From: Simon Davis
Sent: 04 October 2017 17:28
To: Planning.Responses
Subject: FW: Y/52/17/DOC - Longacre, Maypole Lane

Planning Application Ref: Y/52/17/DOC (2) (prev Y/5/16/PL) *Current comments in blue typeface*

Location: Longacre, Maypole Lane, Yapton

Description of works: Seeking discharge of Conditions

Drawing title: Tree Protection Plan

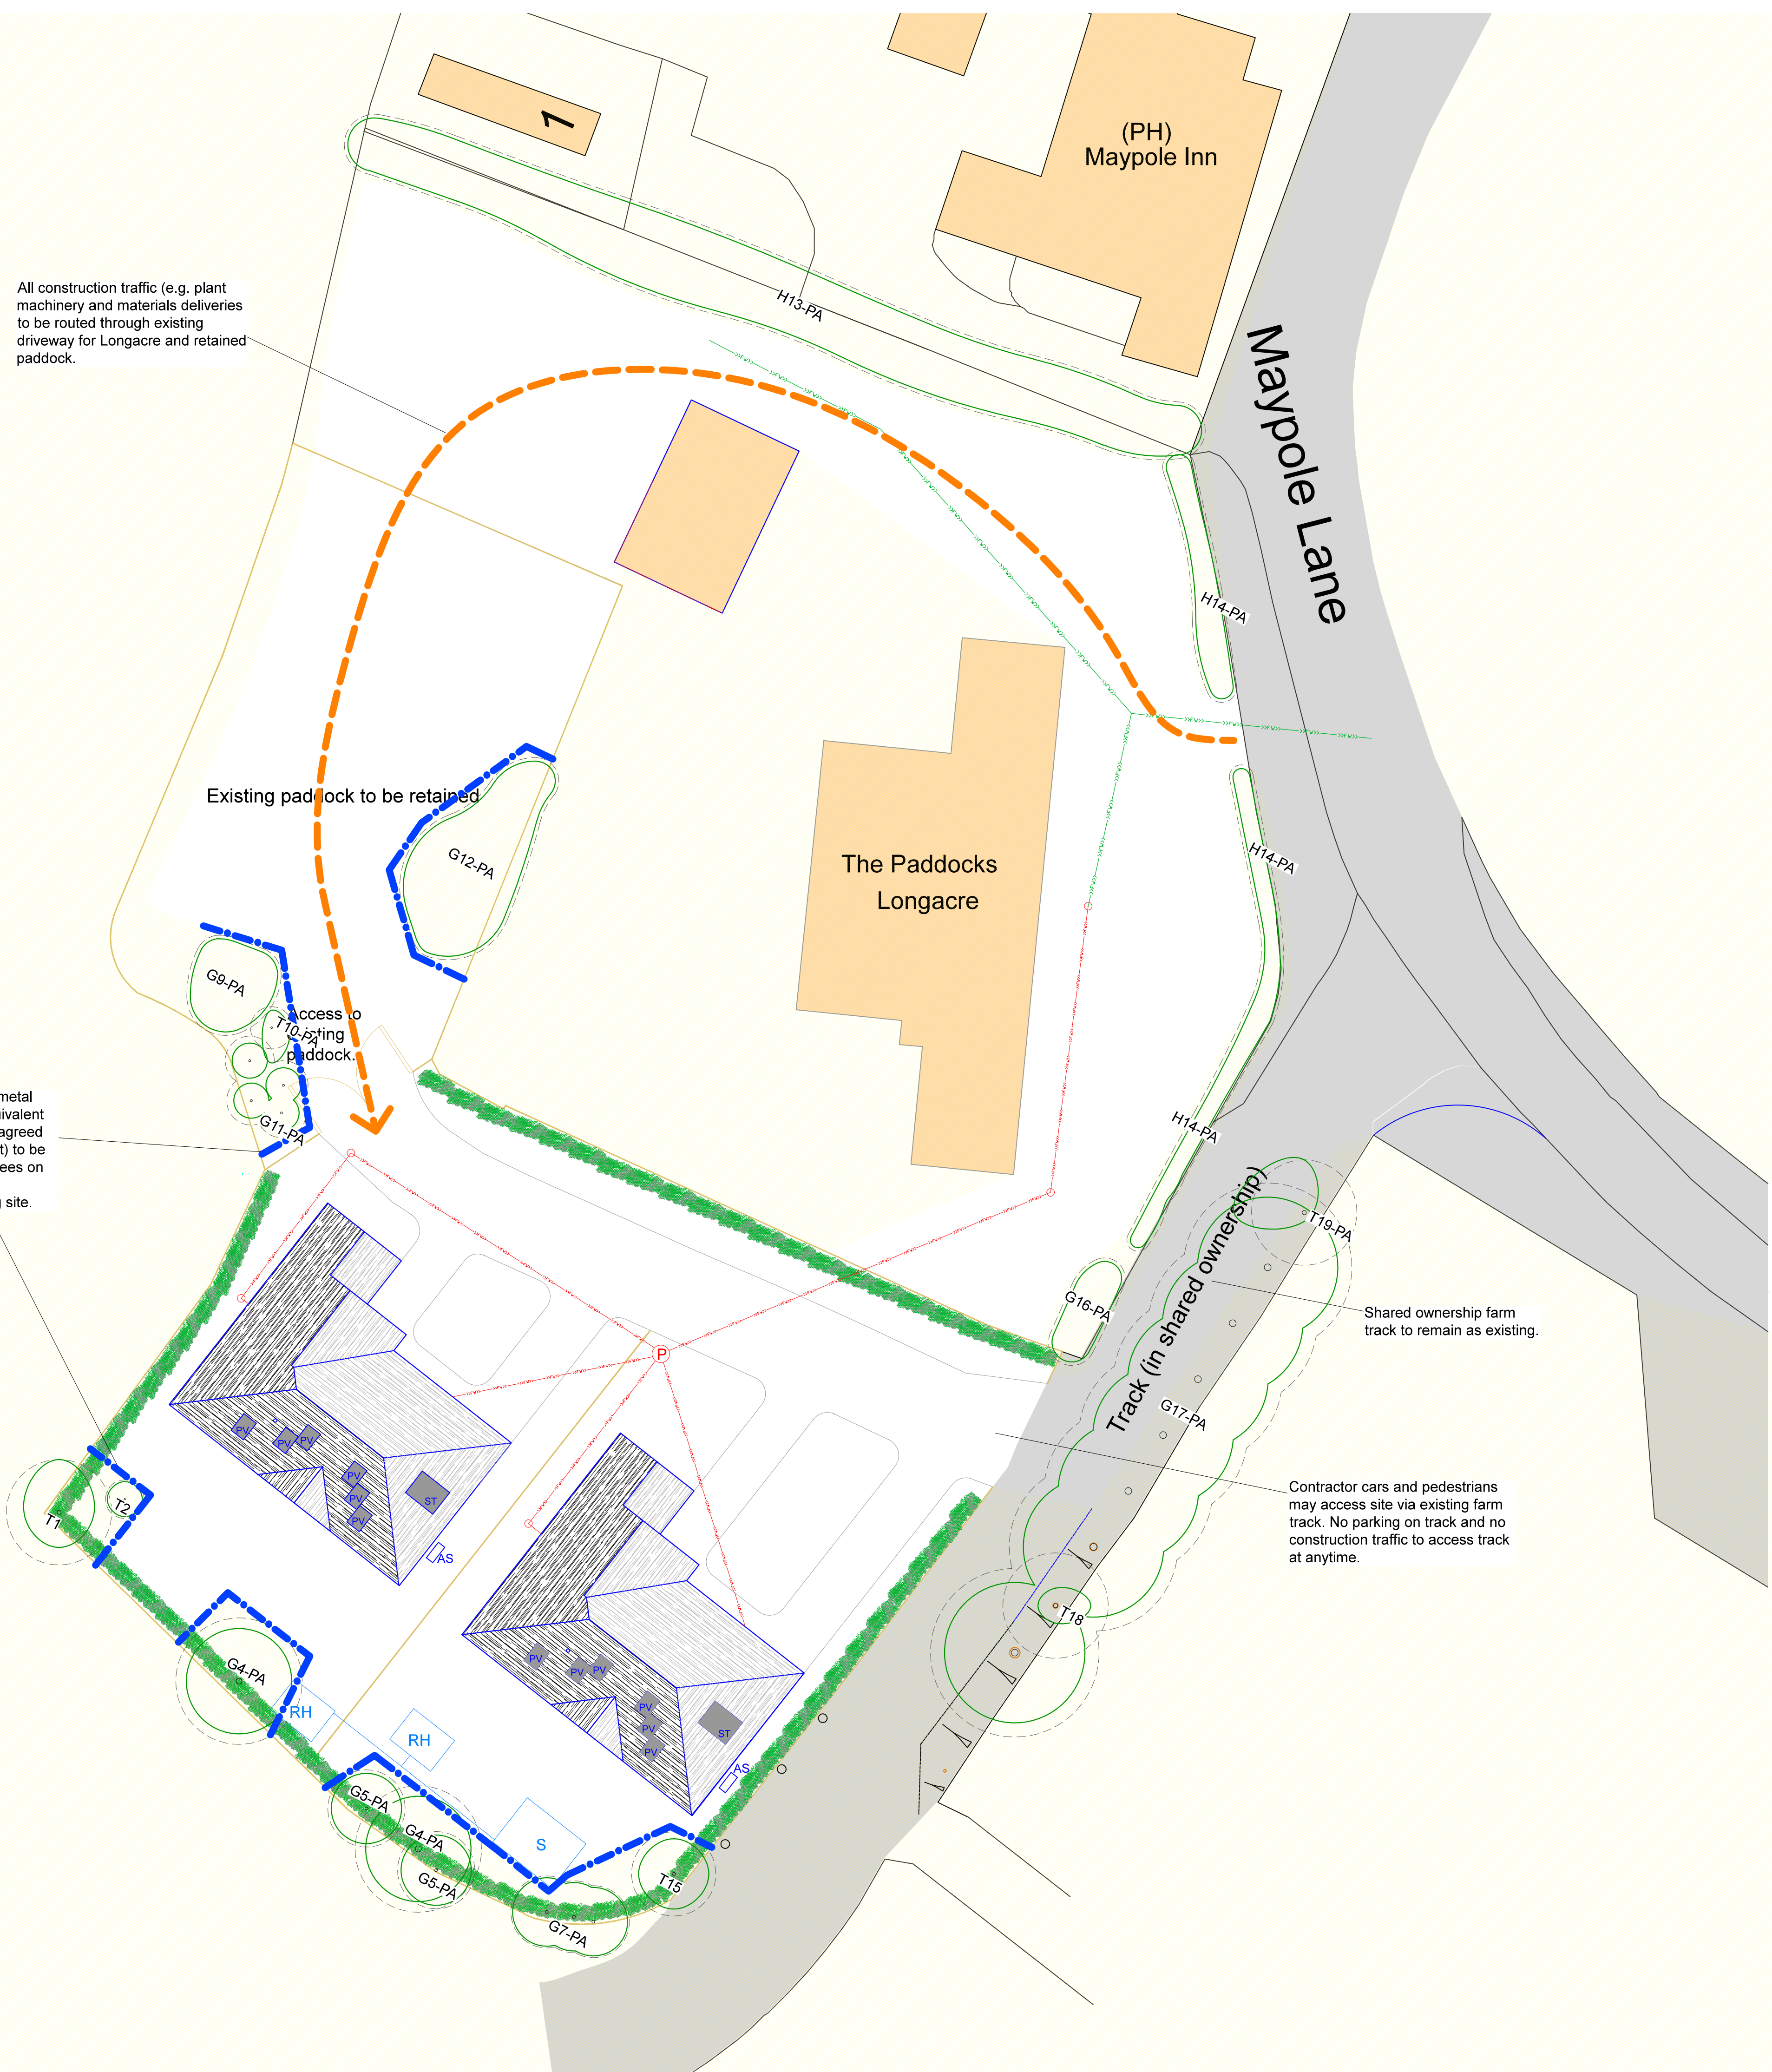
- Regrettably I am still unable to sign off on this Condition because although the HERAS fencing panels are fine and they have been firmly clamped together they have not been secured in place and can thus readily be moved about.
- I would want to see them comply with Figure 3 drawings of BS5837 with back stays in place secured in the ground with road pins road pins driven through them and also through the holes in the front and back of the rubber mounting blocks

- Seek amendments and then resubmission of photographic evidence of compliance.
